**Consultation Response from KC,
Conservation & Design**

2025/93126 The Coach & Horses, Eastgate, Honley, Holmfirth, HD9 6PA

**Demolition of rear block, erection of rear extensions and alterations to existing building to form
9.no apartments including associated works and alterations (within a Conservation Area)**

Date Responded: 14/1/26

① Existing South-East Facing
 Elevation
 1:50

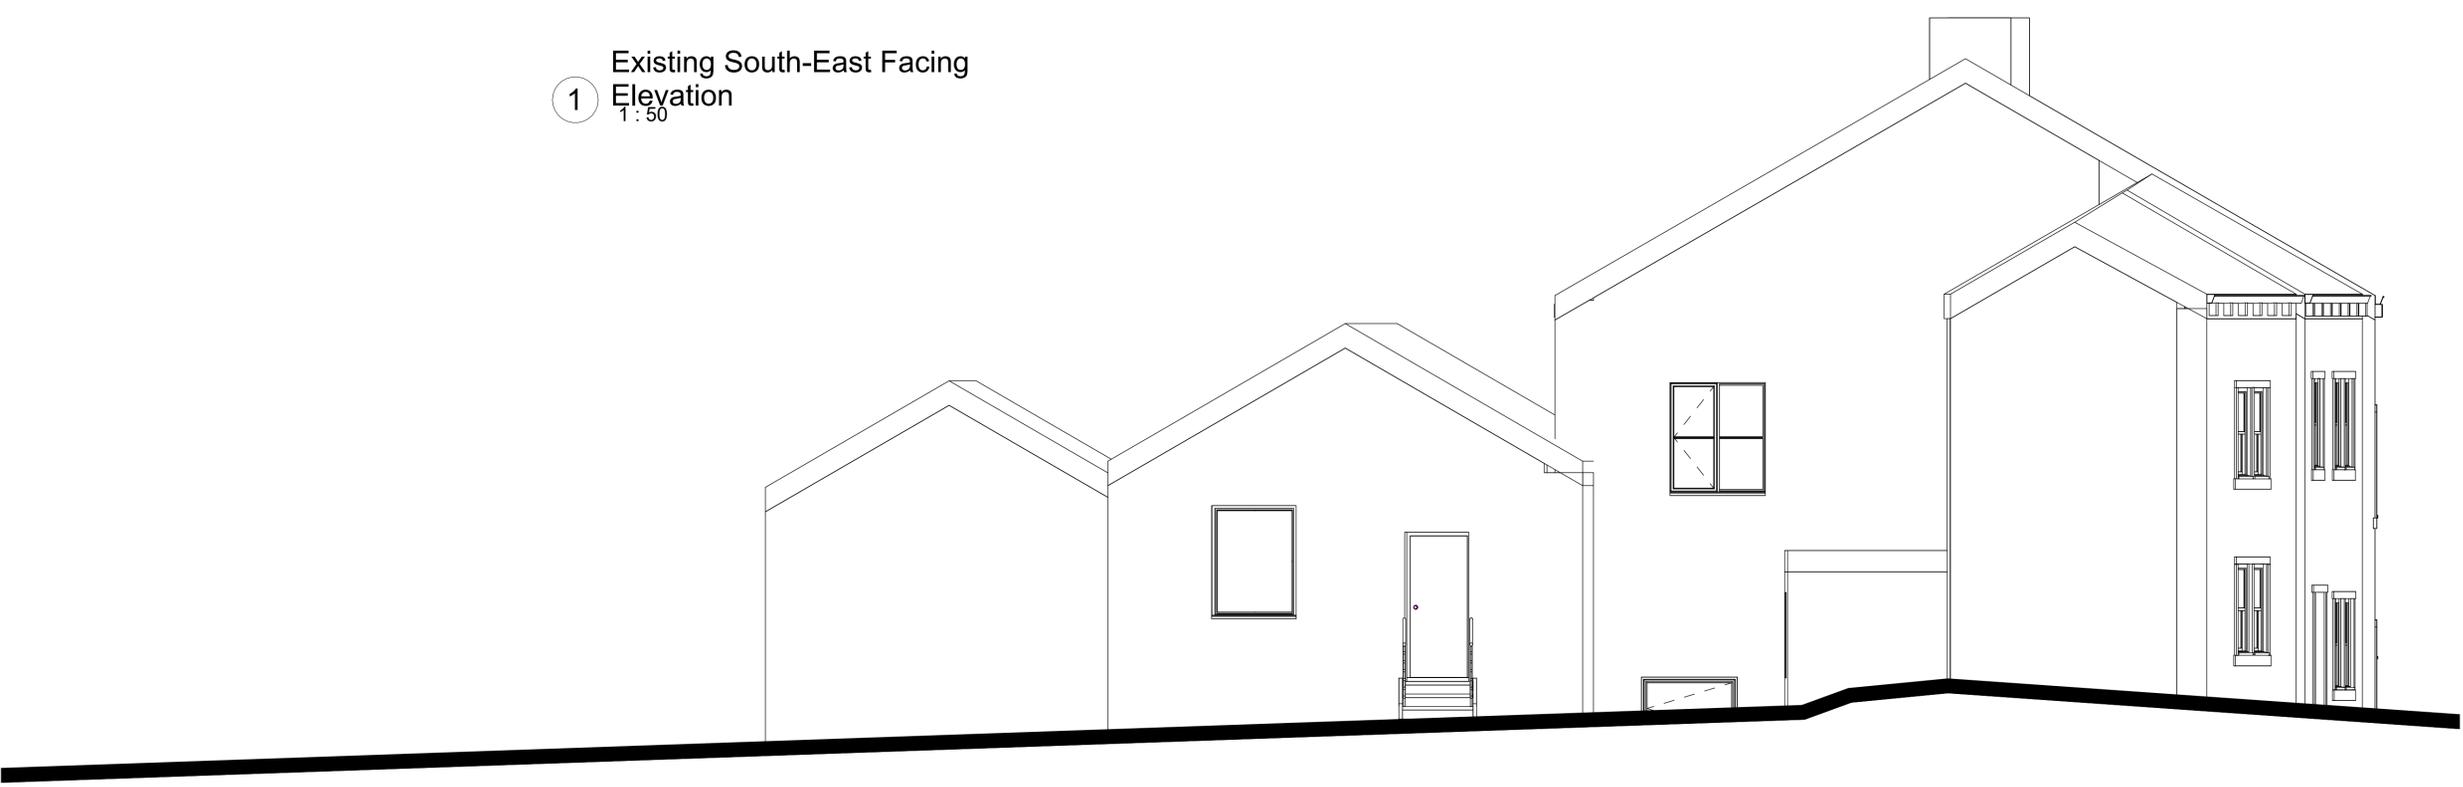
The proposal to retain the main building and frontage are welcomed. The above features are very important to retain. The existing and proposed plans have omitted the stone roof copings and a chimney on the left which should all be retained. The roof to the left appears to be proposed to be extended in height and omits the chimney which should be retained. It should be demonstrated that the character of the front elevation would not be altered, by the roof extension. It would be hard to obtain sufficient natural stone slates to match. Please seek confirmation that the front masonry walls would not be extended in height. The gable end is proposed to be constructed in natural stone masonry. Can the chamfer feature at the end be retained? The stone must be conditioned to match existing as closely as possible in terms of stone source, colour, texture, size of coursing, finish and the courses to line through.

1 Proposed Ground Floor Plan  
 1 : 100

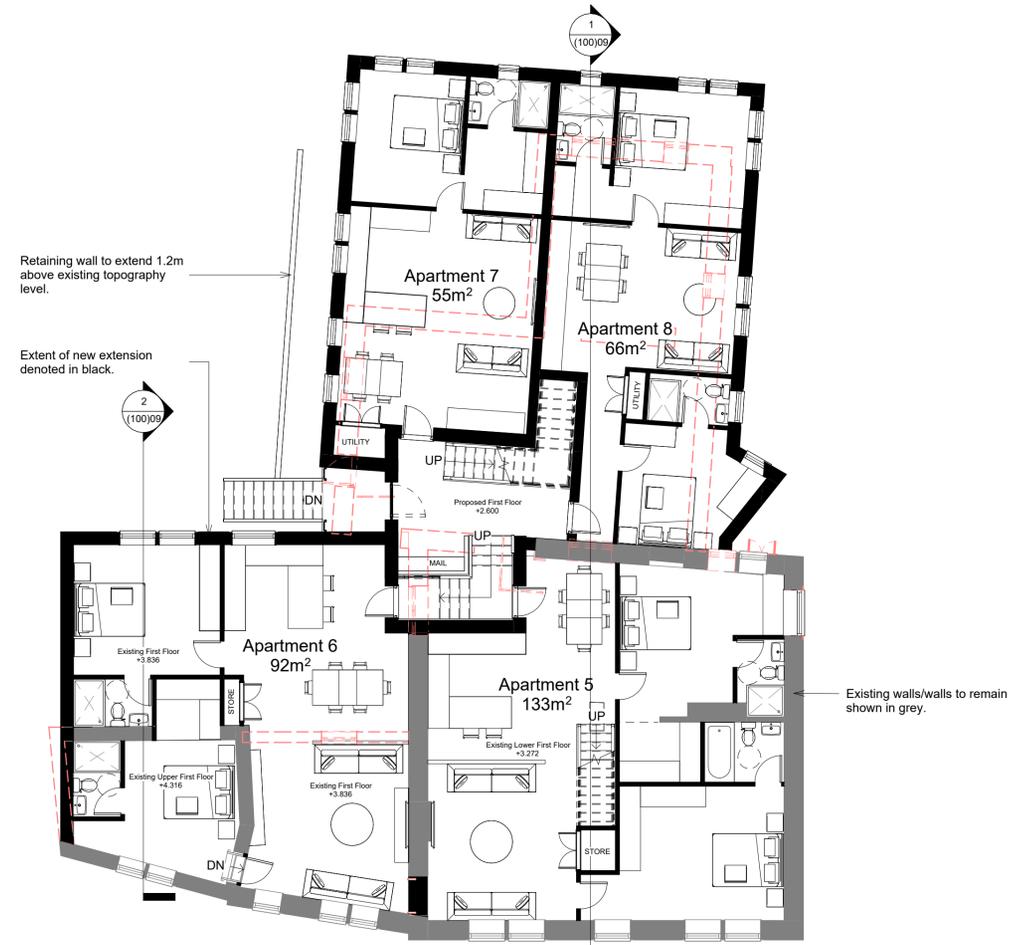
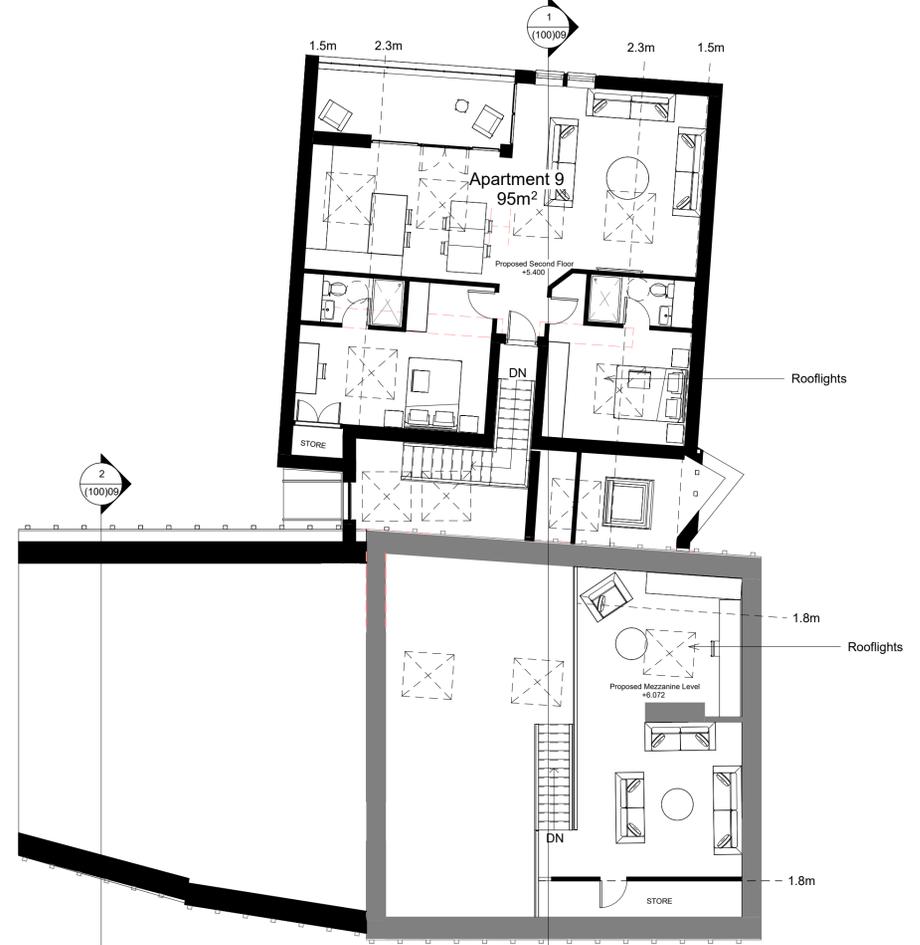
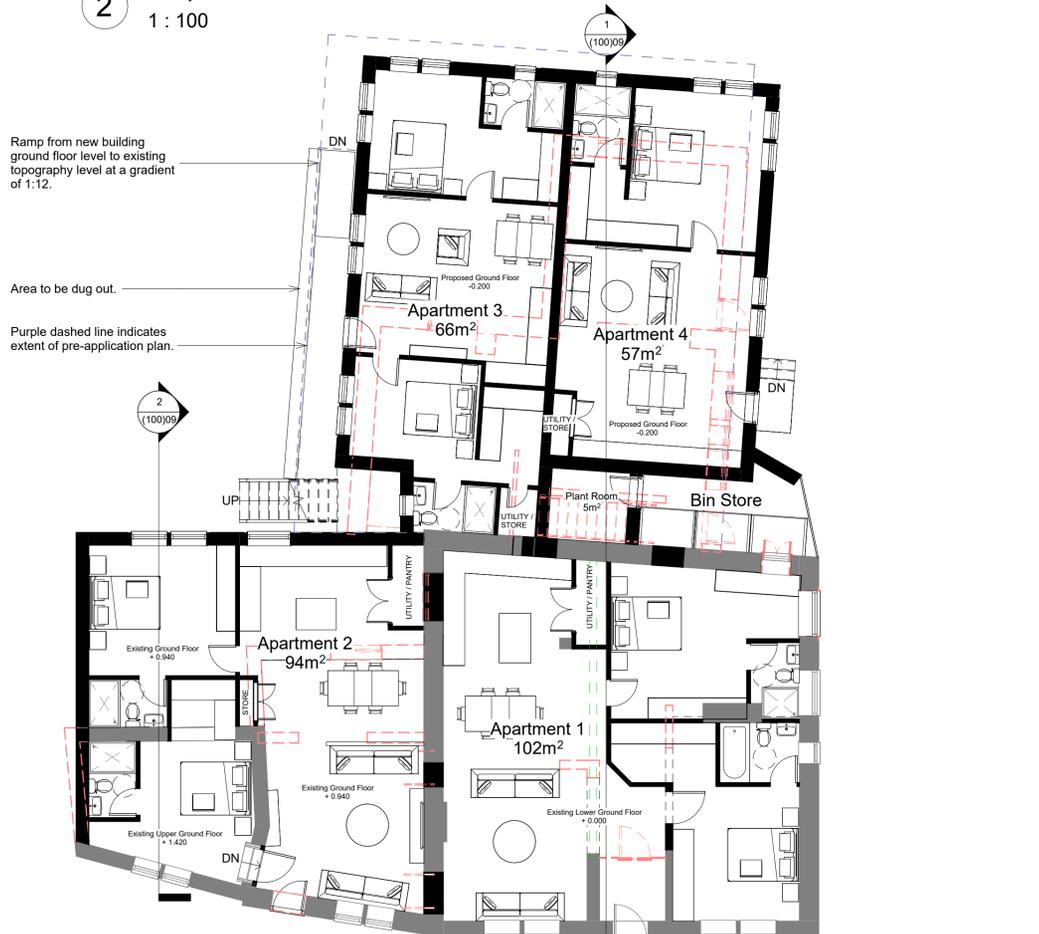
The proposal to demolish the later and much smaller rear extension is considered acceptable in this case. However, the new proposed extension is large and needs to be more subservient in terms of length and width. The length could partly be reduced further by omitting the balcony section. This high-level balcony area contributes to an increase in the footprint of the extension causing a larger scale, bulk, massing and form than is appropriate or proportionate to the original building. There are linked concerns around privacy/overlooking issues caused by the high-level balcony in relation to existing properties too. Therefore, it is requested that a reduction in size of the extension length and width be sought including omission of the high-level balcony.

Front boundary treatment would be important and archive images could be researched for the frontage. A new low stone boundary wall with coping could be appropriate including some appropriate soft landscaping at the front. Allocation of some landscaped outdoor amenity/sitting space for

residents at the rear would be encouraged. Retention and or re-use of stone setts at the front could be considered appropriate. Could more bins be sited at the side or rear to reduce the clutter and impact on the front elevation and Conservation Area?

1 North-East Facing Elevation
1 : 50

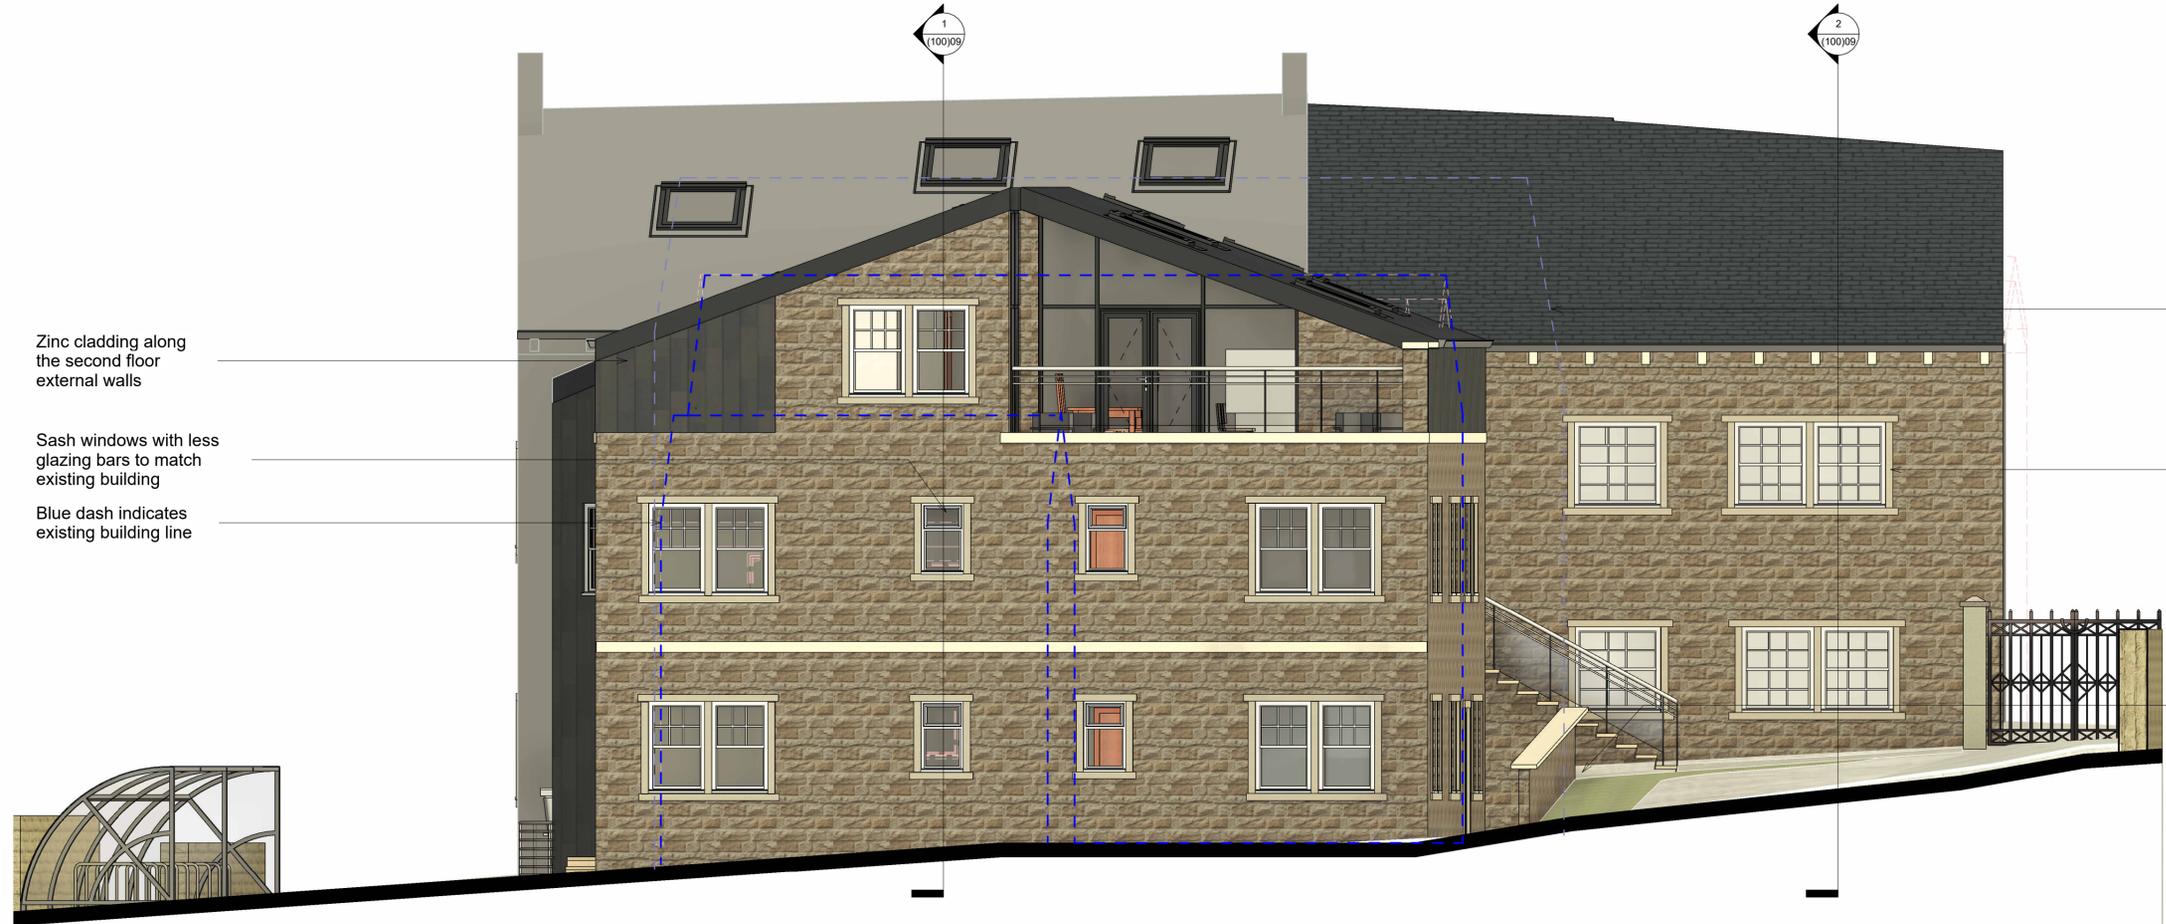
Proposals should aim to preserve or enhance the Conservation Area. The retention of the character of the existing front block is expected and this should retain the small paned Georgian style windows ie 6 panes over 6 panes. Original windows could be repaired, and use secondary glazing, or if the windows are in poor condition, a good quality timber slim-lite double glazed sliding sash using the correct proportions could be considered. Archive research could confirm the original window pattern for the left building which could be Georgian style to match existing. Good quality timber Georgian style doors at the front should be encouraged and conditioned. A 6-panel door is appropriate on the left, and similar should be proposed on the right

The windows in the extension do not need to copy the Georgian style windows but could use a similar but simpler arrangement with fewer glazing bars. The use of a good quality matching natural stone for the rear extension would be encouraged and conditioned. The existing natural stone slates should be retained for the front building and if needed re-laid in diminishing courses to match existing.
